**Watermark Coal Project SSD4975: adequacy of Environmental Impact Statement (EIS)  
Part K (Ecological Impact Assessment) and Part L (Koala Plan of Management)**

I write to provide comment on the above components of the EIS prepared by Cumberland Ecology to accompany the development application for the Watermark Coal Project SSD4975.

Figure 3.1. Updated Grassland/Agricultural Area Mapping of the Disturbance Boundary

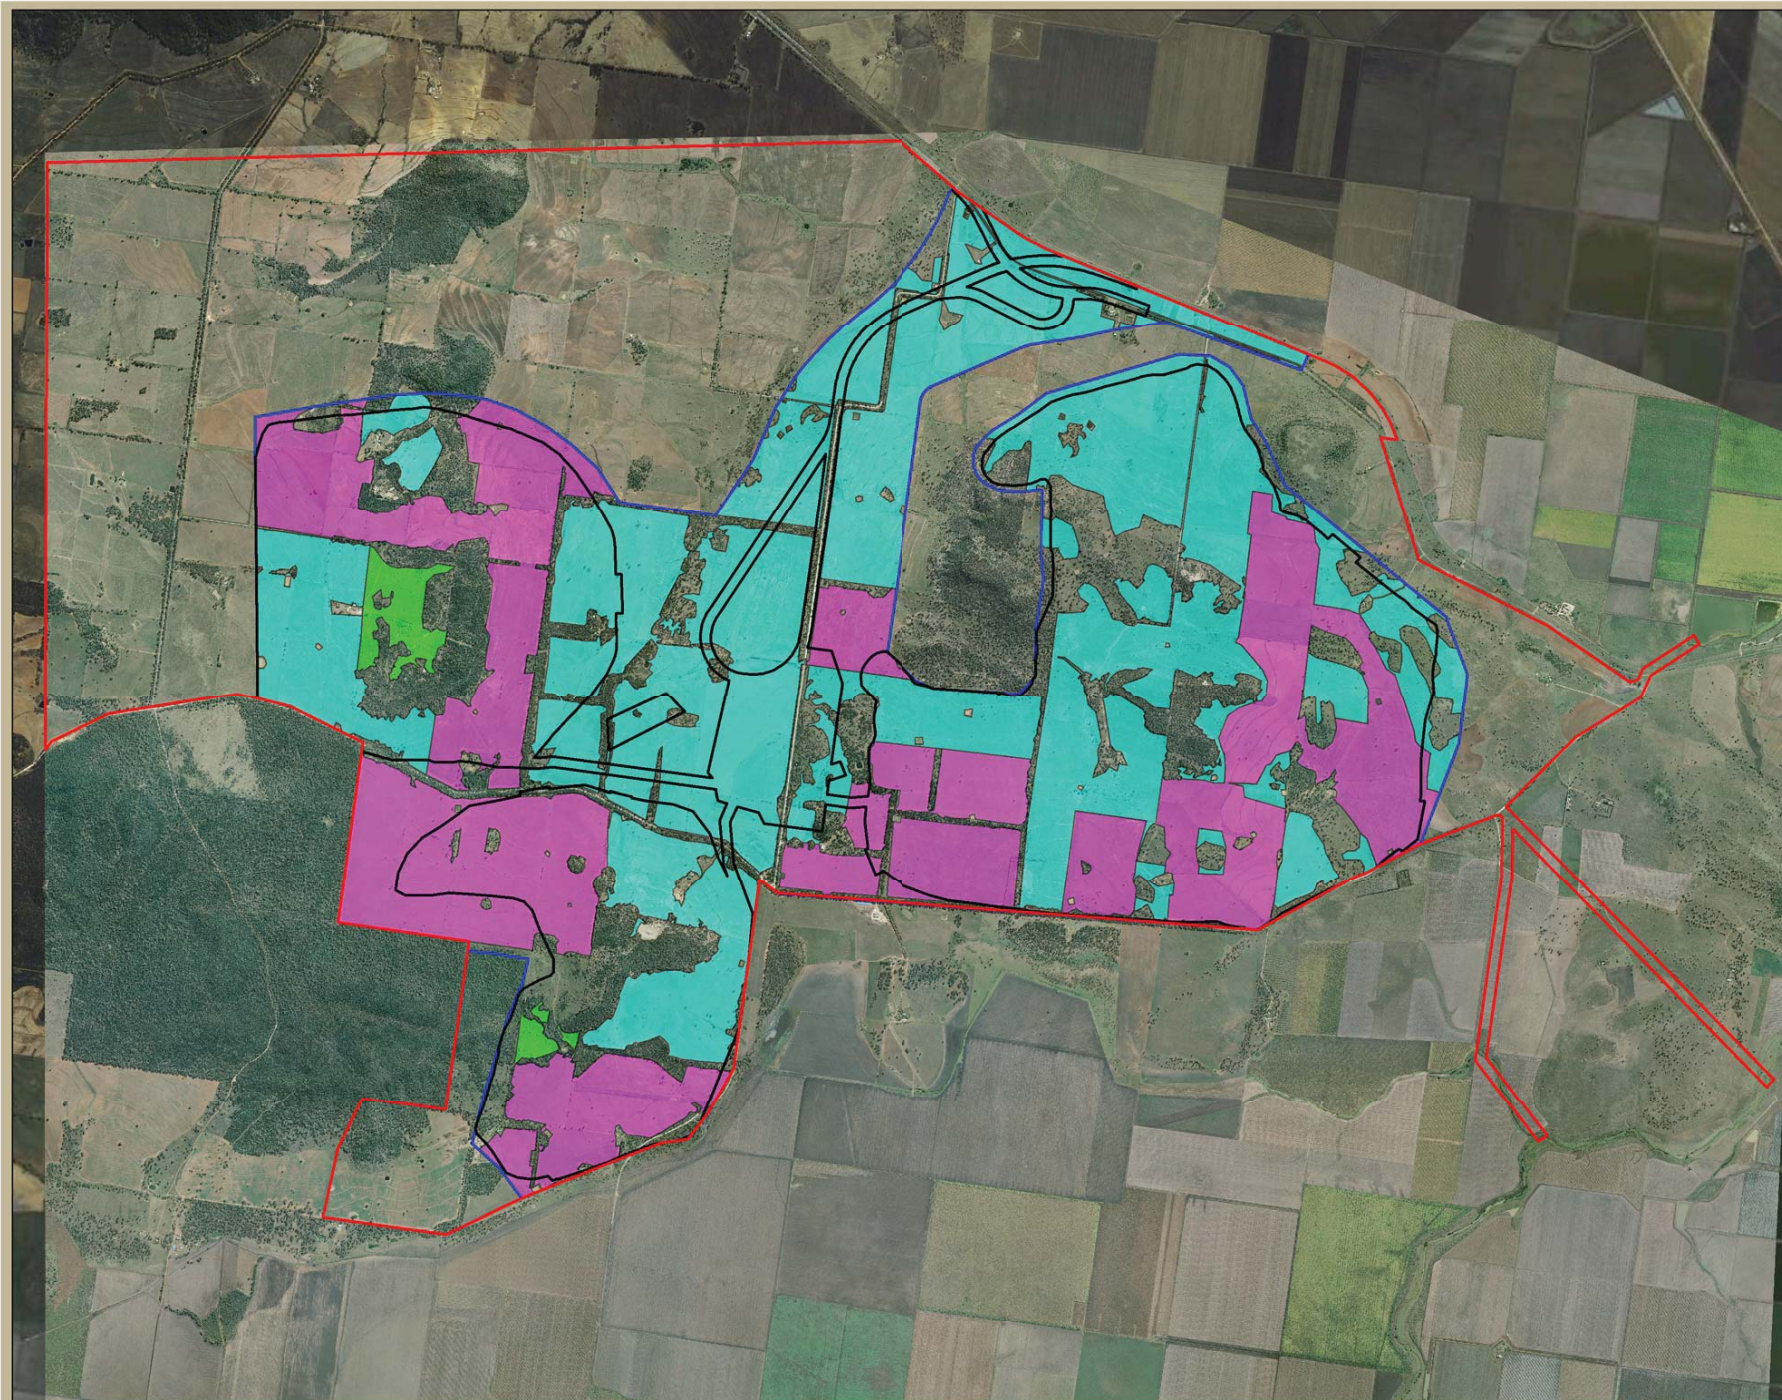
It is also likely that the SEVT on Mt Watermark is more extensive than shown in Figure 3.1 of the Ecological Impact Assessment. Throughout the North West Slopes, SEVT commonly grades into nearby shrubby eucalyptus communities (per. obs.; Keith 2004), resulting in intermediate forms which are often mapped as vine thicket (Keith 2004). During my doctorate I sampled three 20 x 20 m quadrats on Mt Watermark (Curran 2006). Two of these plots were immediately below the cliffs on Mt Watermark, where the majority of the SEVT is likely to be, but one was in a gully on the mid-slope of the north-facing slope of the mountain. I am happy to provide further details of these sites if requested.
